# CITY OF ALBUQUERQUE

PLANNING DEPARTMENT – Development Review Services

**RE: Sevilla @ Andalucia - (File: F11D015C)**  
**Drainage Management Plan, Engineer's Stamp Date 1-19-2015**  
**Grading and Drainage Plans, Engineer's Stamp Date 1-19-2015**

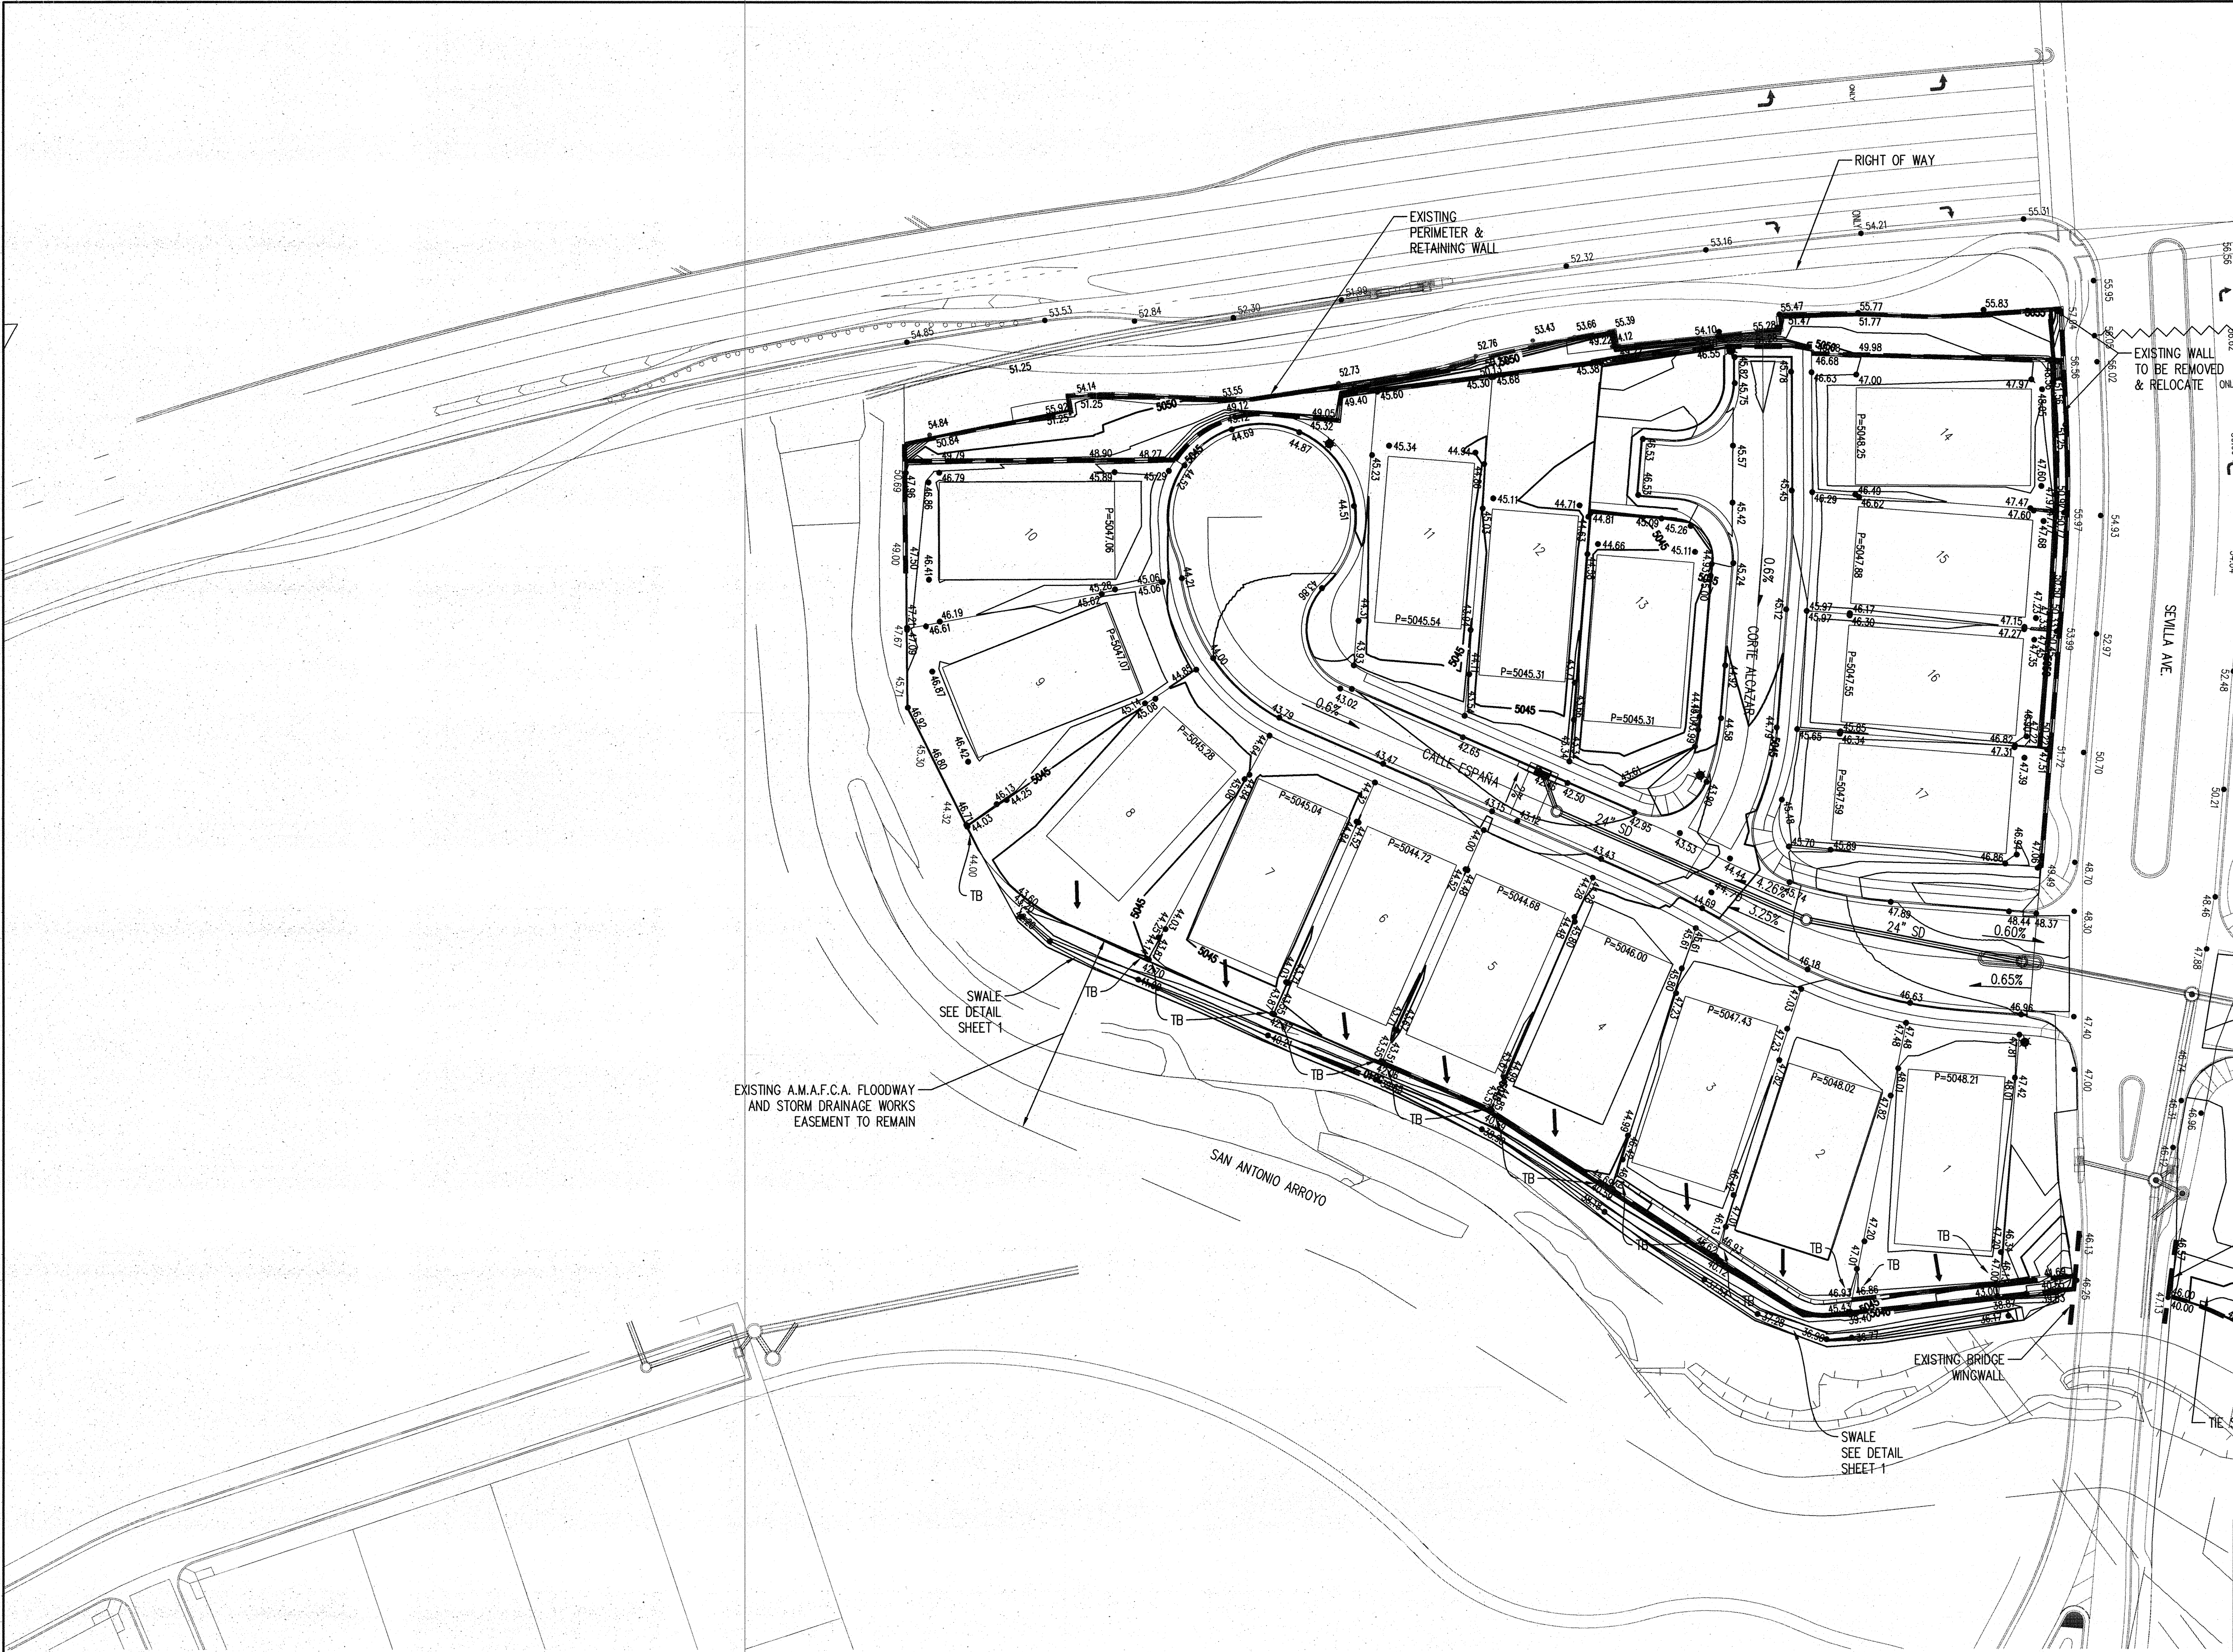
1. Open space tract ~~at~~ Basin D-1 should drain to cul-de-sac at far south end via turned blocks or other means.
